Appendix C

Response to 50 Murray Street Submission

The following comprises a detailed response to each of the key items raised in the 50 Murray Street (ONE Darling Harbour) submission prepared by Beatty Legal and dated 11 May 2020 and supporting Visual Assessment prepared by RLA and dated 8 May 2020. The proponent's responses have been informed by input by the expert consultant team and should be read in conjunction with the Response to Submissions Report to which this document is appended.

Image 82 Envelope Plan

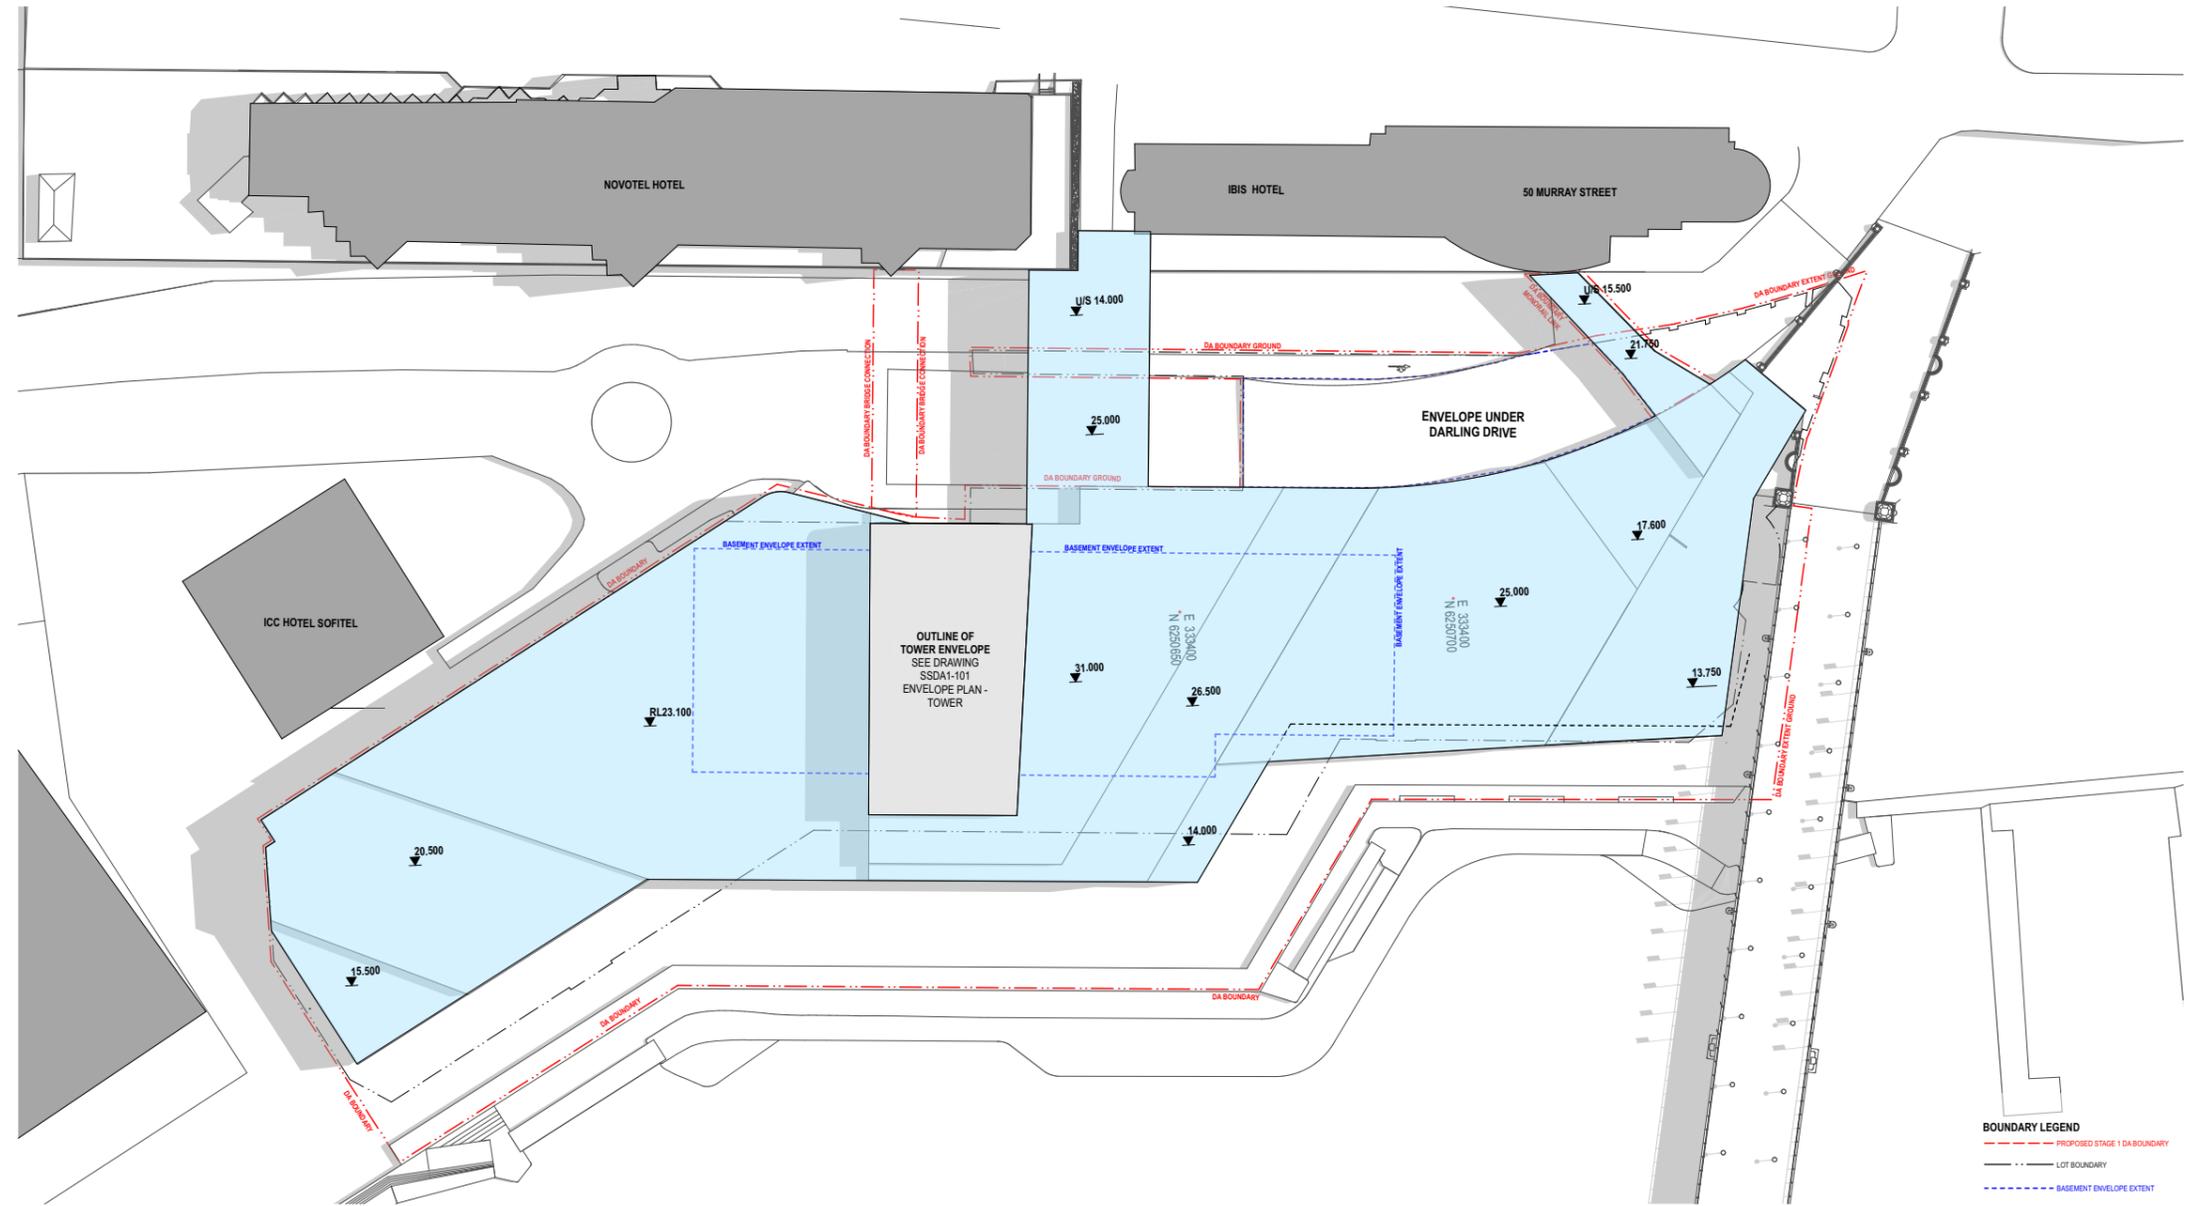
<p><i>In my opinion the height and the east-west depth of the northern section of the podium causes significant view loss that has not been acknowledged and should be reconsidered, if the overall strategy for redevelopment, with a podium-tower building is accepted. These features of the proposal do not achieve a reasonable view sharing outcome.</i></p>	<p>Disagree.</p> <p>The interruption of existing private views that are currently unimpeded by any development is inevitable in the context of an urban renewal project and is not unreasonable having regard to the highly urbanised global CBD environment of Sydney within which the land is situated and the evolving future character of the Pyrmont Peninsula. Notwithstanding, the proposed development has accommodated view sharing between and above buildings, and has sought to retain a reasonable level of water, Pyrmont Bridge, and CBD skyline views by the positioning of the building footprints and configuration of the public domain spaces and connections through the site.</p> <p>This conclusion fails to recognise that the proposal provides for the establishment of significant new spaces and areas for the broader public/community to enjoy and experience the waterfront location of Darling Harbour and that it needs to be balanced against the retention of views from the private domain. This is consistent with the aims of the Sydney Harbour REP which articulates that the public good (public views) take precedence over private good (private views) where change is proposed on the harbour or within its foreshores.</p>

<p><i>The height, depth from east to west, massing and height of the podium adjacent to the north edge of the tower needs to be properly justified, based on accurate, comprehensive and representative photomontages or CGIs, based on surveyed view locations. Only when adequate information is provided, can a full assessment of view sharing be undertaken. Currently there is no adequate assessment of view sharing provided in the documentation assessed in this report.</i></p>	<p>All potentially impacted apartments within 50 Murray Street have now been assessed within the revised Visual and View Impact Analysis.</p> <p>The analysis is based on a comparison of existing and proposed views experienced from each apartment with an easterly orientation.</p> <p>The principles of <i>Tenacity</i> have been applied in reaching an overall impact category/classification for each apartment.</p> <p>The views analysed are considered to have been appropriately described, valued and the level of impact reached applying the principles of <i>Tenacity</i>.</p>

**Figure 19** 50 Murray Street – worst affected apartments

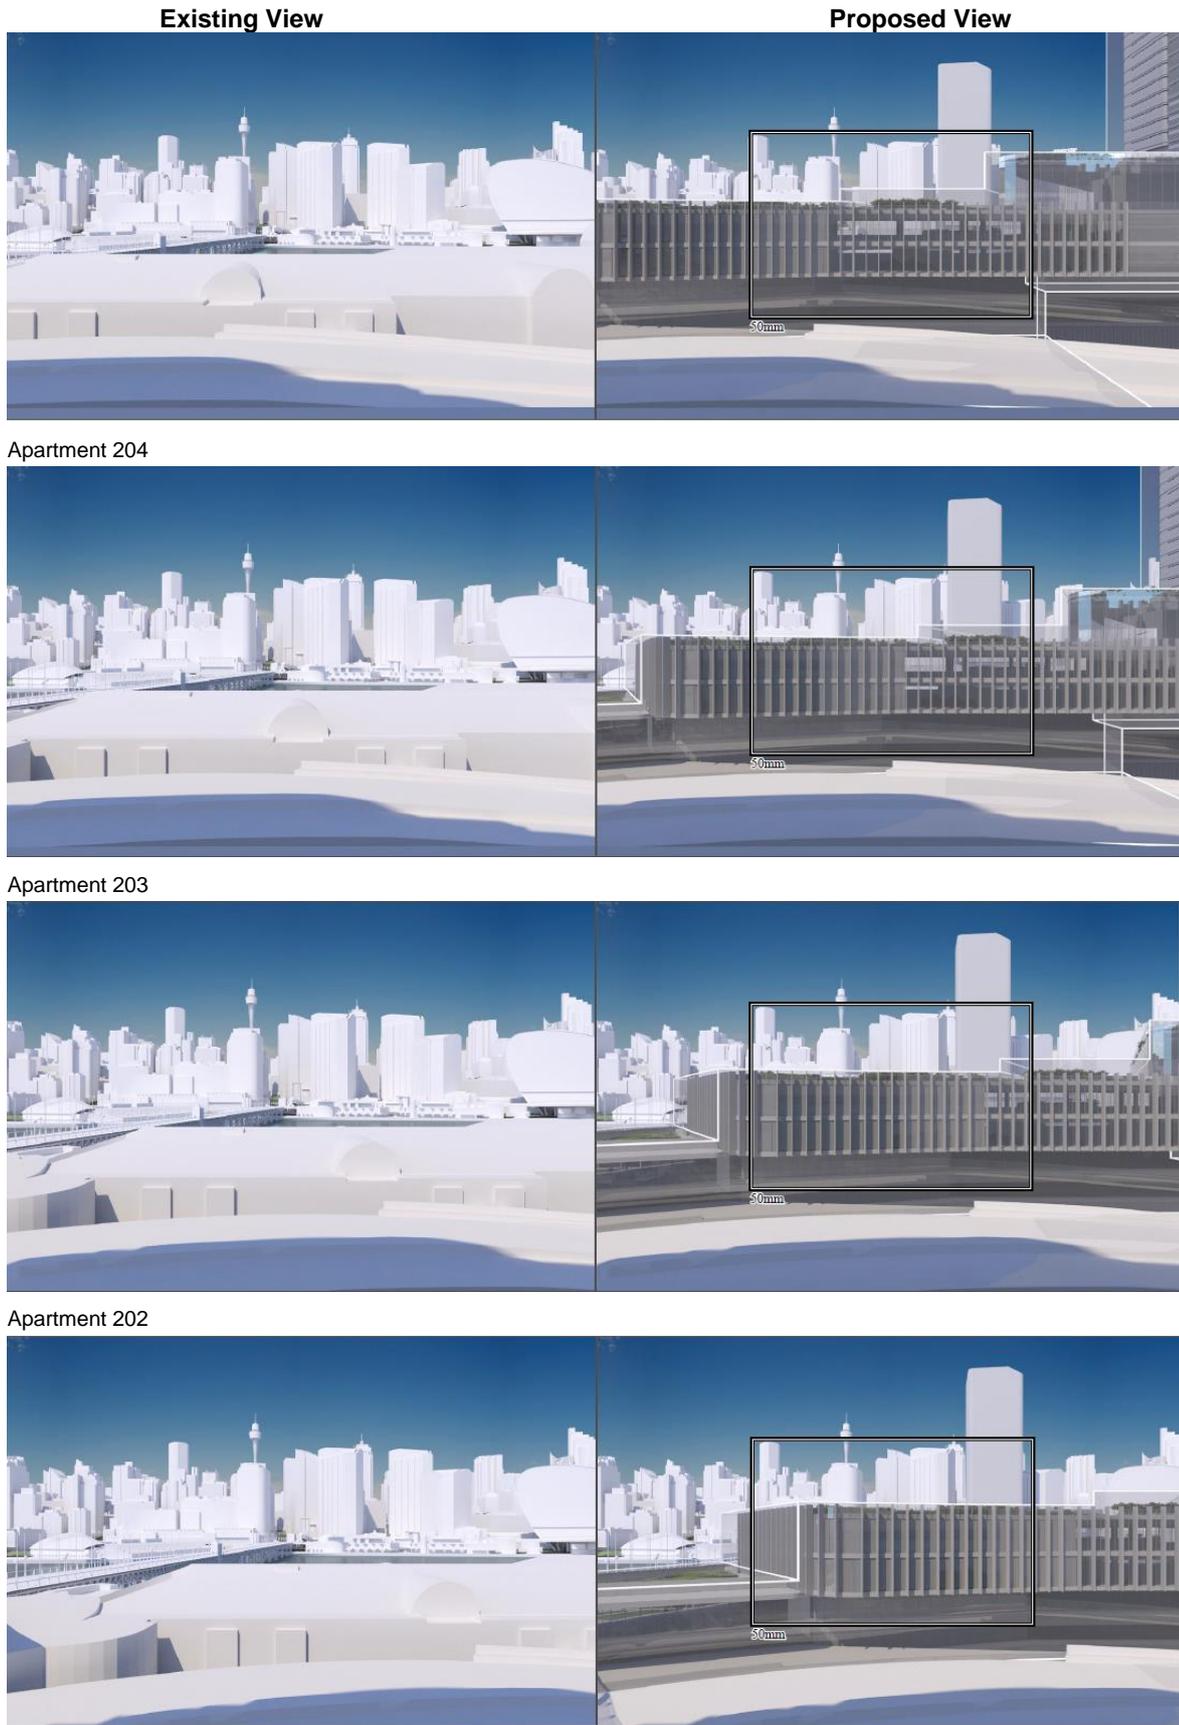
<p><i>The assessment of view impacts for the residents of One Darling Harbour provided by the proponent is inadequate both in the coverage of the views and reliability of the images generated and in the quality of the analysis.</i></p>	<p>All potentially impacted apartments within 50 Murray Street have now been assessed within the revised Visual and View Impact Analysis.</p> <p>The analysis is based on a comparison of existing and proposed views experienced from each apartment with an easterly orientation.</p> <p>The principles of <i>Tenacity</i> have been applied in reaching an overall impact category/classification for each apartment.</p> <p>The views analysed are considered to have been appropriately described, valued and the level of impact reached applying the principles of <i>Tenacity</i>.</p>
<p><i>We also note the uncertainty created by the proposal to include landscape planting on the rooftop of the northern podium. This would add extra height which would add to view loss impacts. This additional view loss has not been assessed.</i></p>	<p>The subject application seeks approval for a concept only (e.g.) building envelope, land use, GFA, along with stage 1 demolitions works. Details such as the nature and extent of landscaping will be progressed and developed through the future planning stages of the project. In any event, consideration of landscaping is not a factor in undertaking a view impact analysis, given they are features of a development that are not fixed like a permanent structure and can easily change (e.g. seasonally, such as a deciduous tree).</p>

Summary of key issues raised	Proponent's response
<p><i>The height of the podium will have severe to devastating impacts on views from One Darling Harbour from Level 2 and six levels above that have been ignored.</i></p>	<p>The findings from the VVIA confirm that the greatest extent of impacts are limited to the low-rise of 50 Murray Street, with the rating of view impacts experienced ranging from negligible to severe.</p>
<p><i>The view sharing analysis report is simply a series of images, not an analysis, and it is of no value with regard to the determination of impacts on view sharing.</i></p> <p><i>The view sharing analysis report does not provide an assessment against Tenacity or any other instrument, provision or guideline.</i></p>	<p>Noted. The purpose of this report was to provide media images only and not to undertake any analysis. Clarification on the purpose of this report has now been made. The view analysis is contained wholly within the Ethos Urban Report, which relies upon the media prepared by Virtual Ideas.</p>
